**CITY OF ALBUQUERQUE  
PLANNING DEPARTMENT**

**June 4, 2014  
DRB Comments**

**PROJECT # 1008265**

**RE: Tracts A-1-A, A-2-A & A-3-A, Journal Center Phase 2**

**SHEET TITLE**  
SITE DEVELOPMENT PLAN FOR BUILDING PERMIT

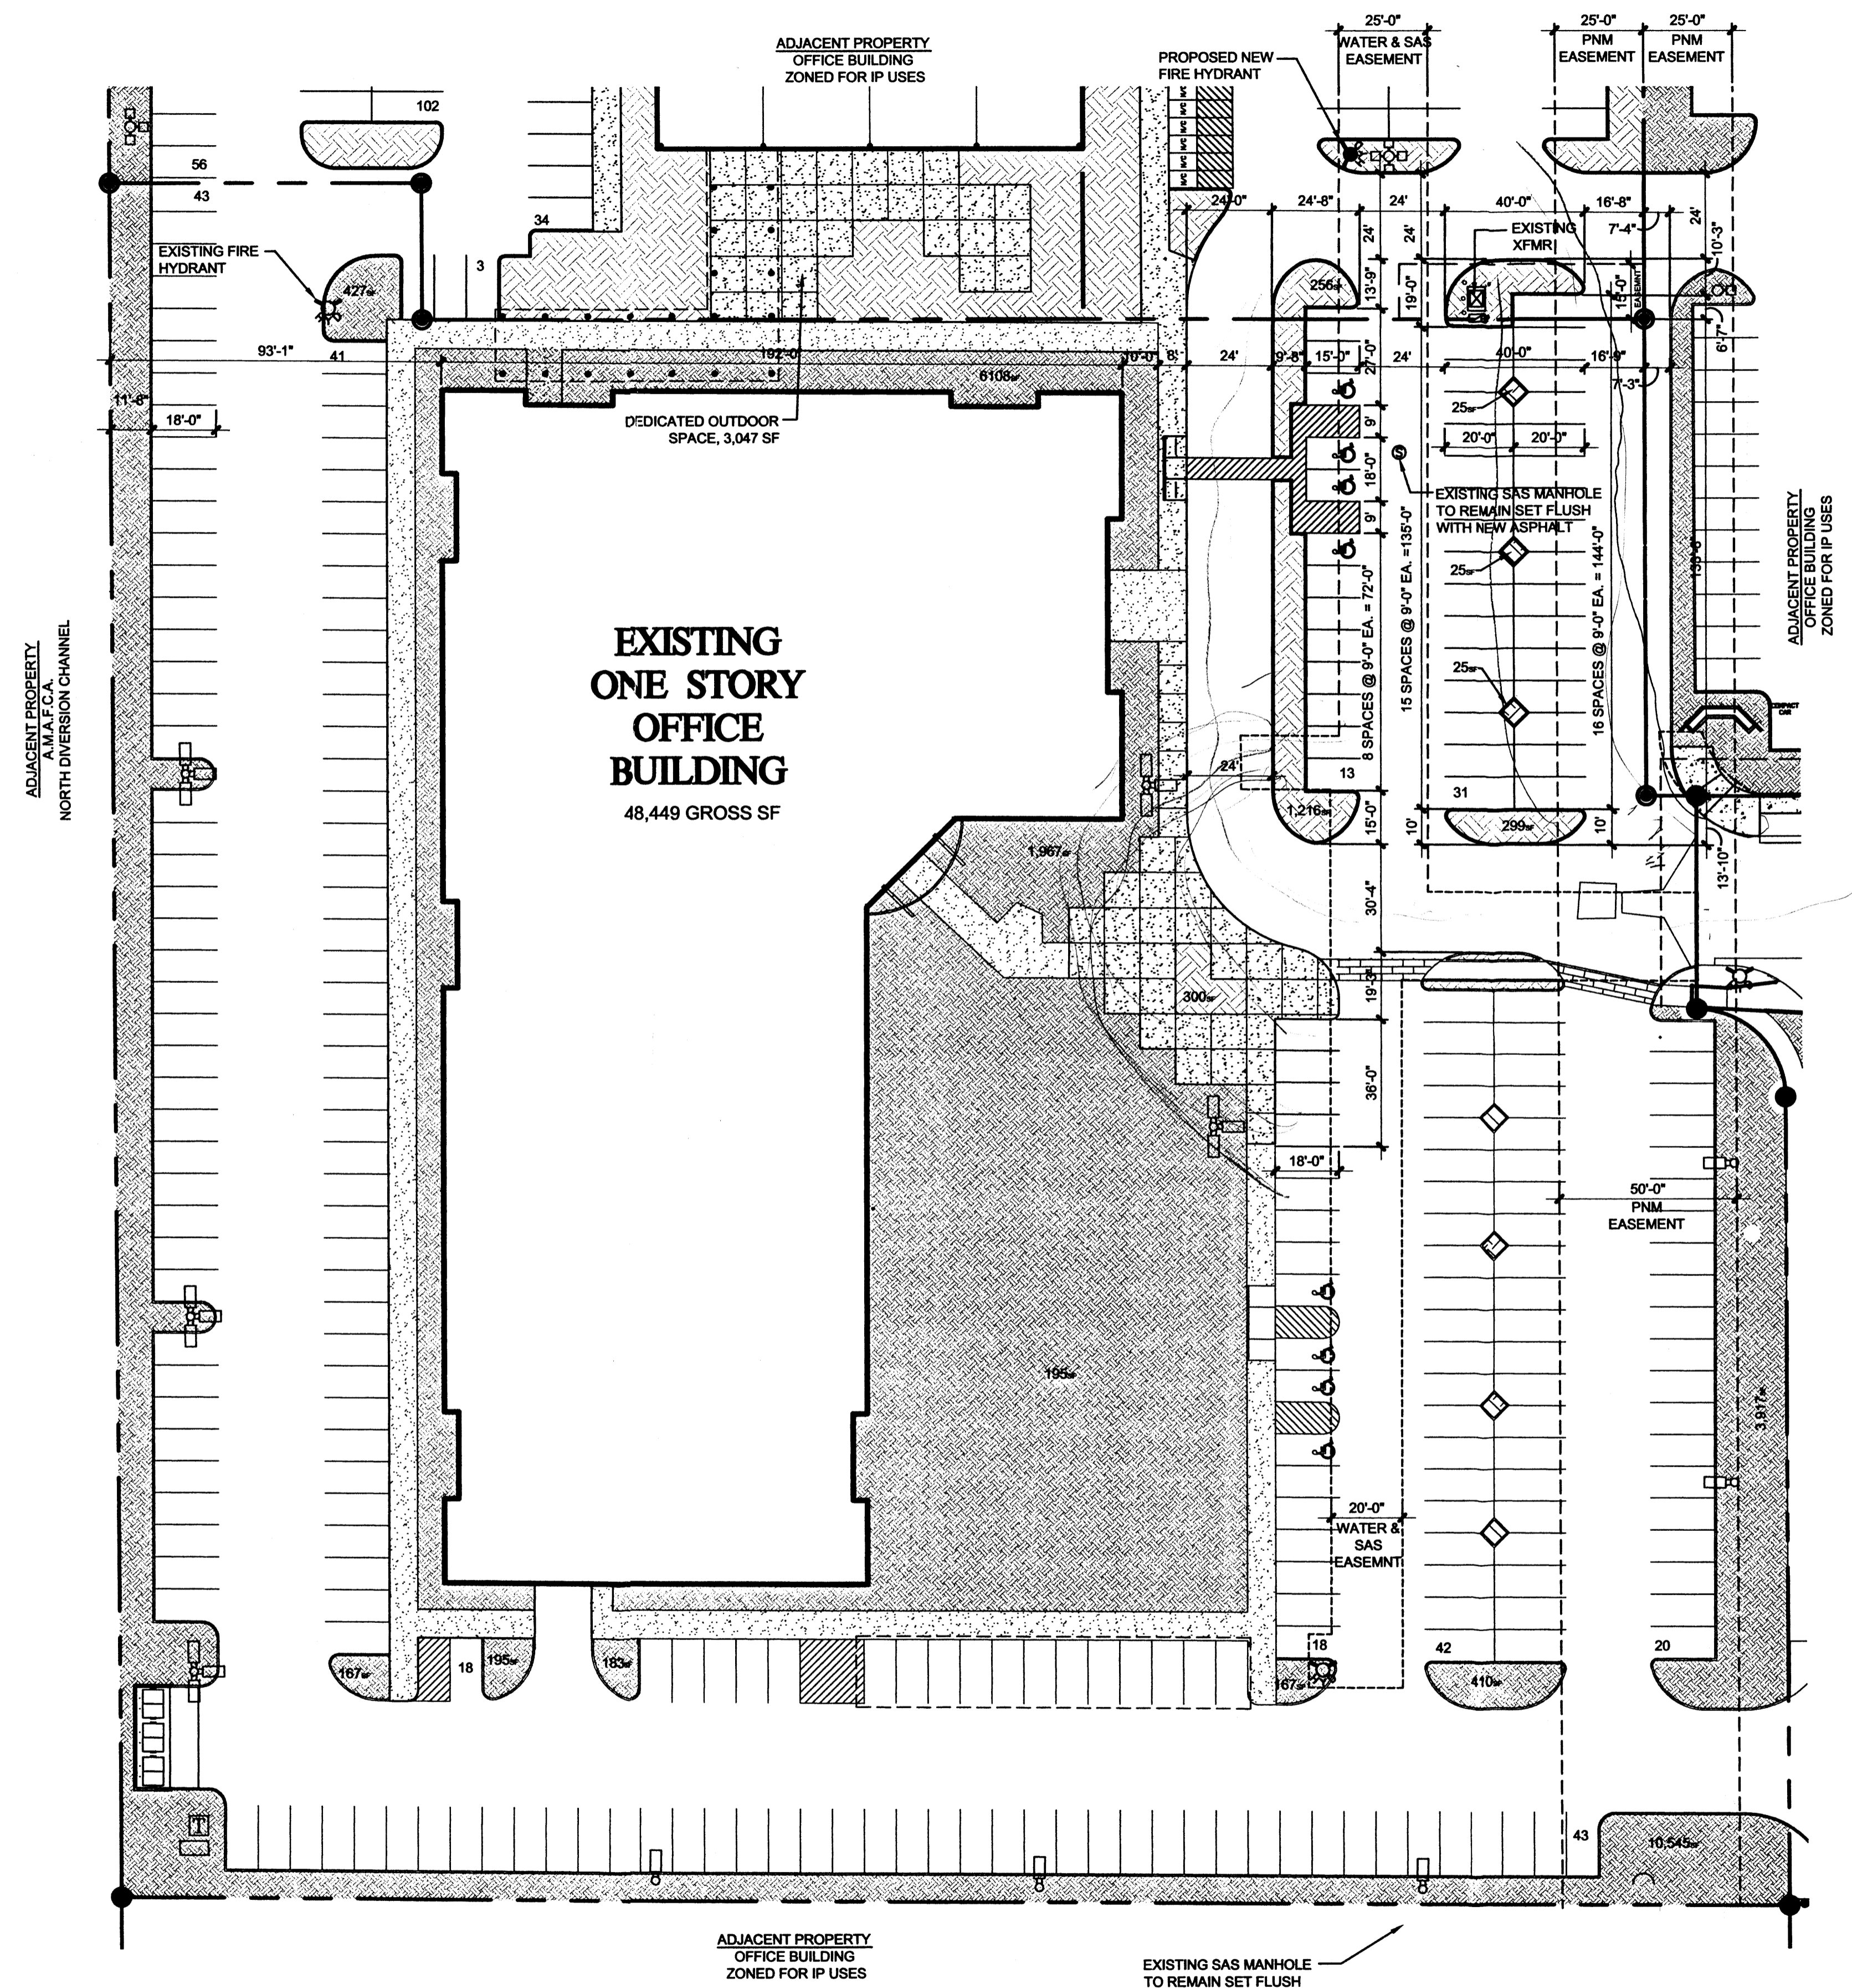
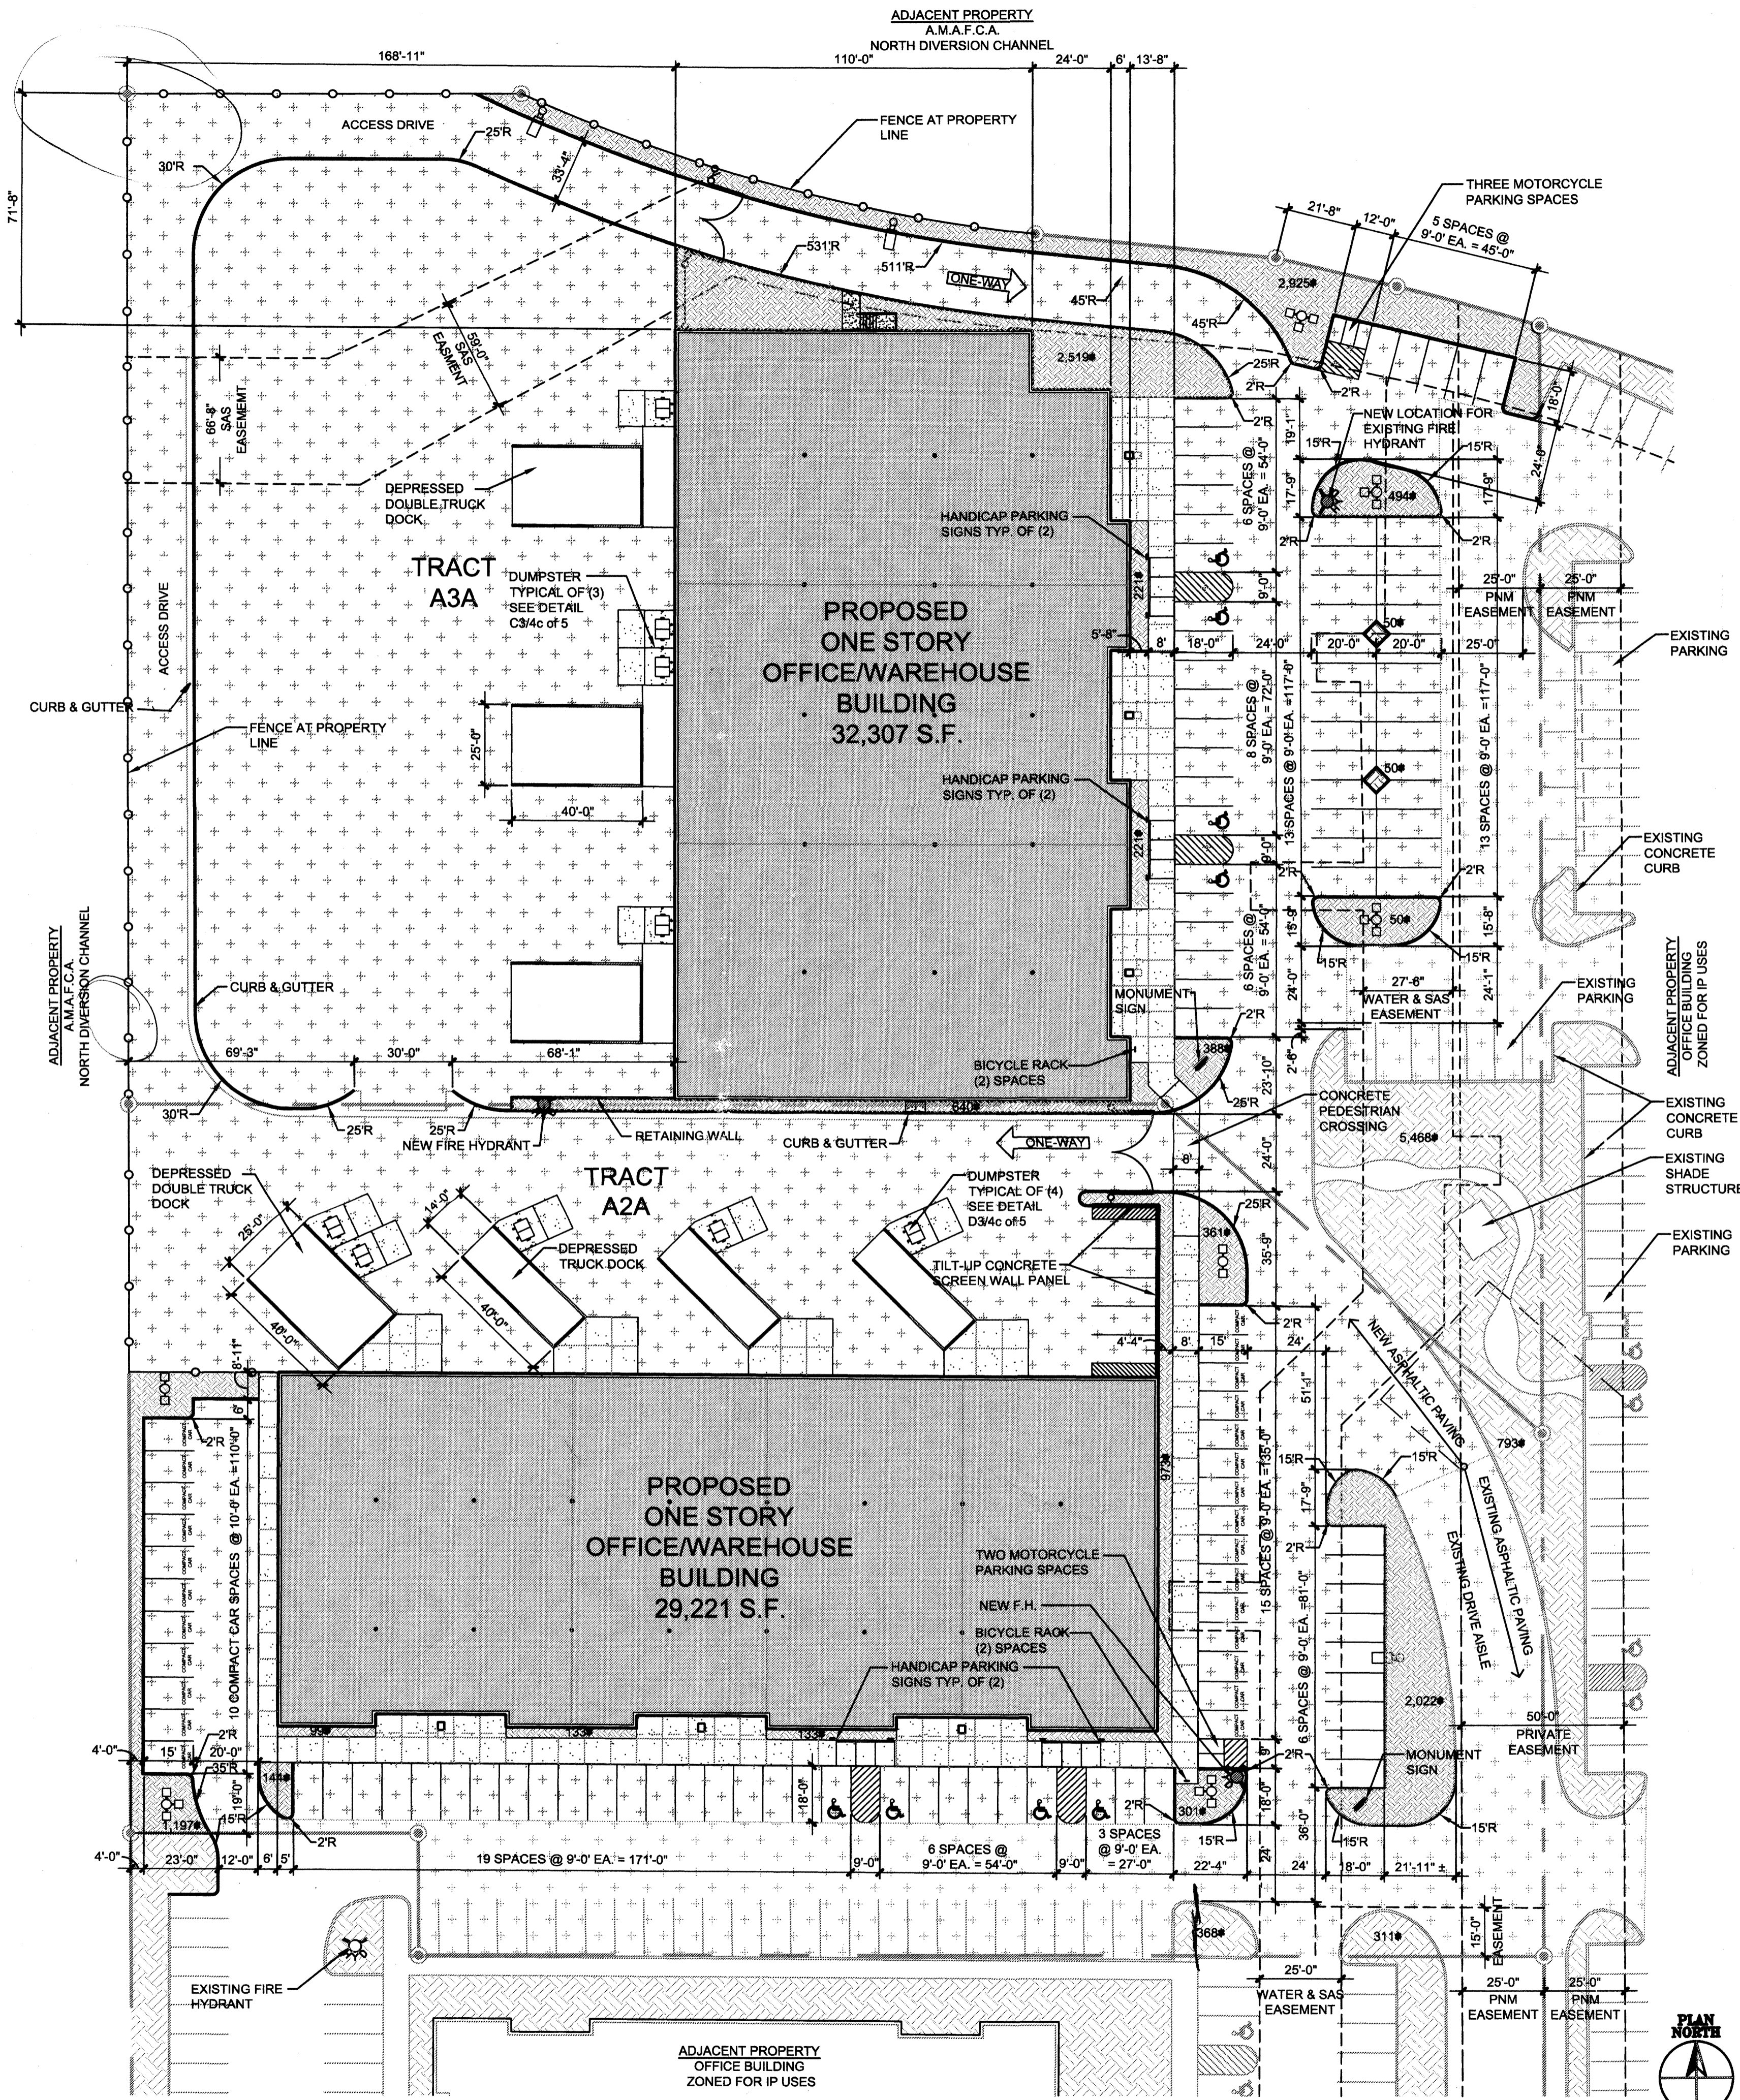
The access thru A-1-A to the new buildings should remain generally located as is, and not placed between A-1-A building and parking, Tracts A-2-A and A-3-A will need to be replatted into a single lot. Relocated shade structure may be required to be on one lot only – verification is needed from Building Permit.
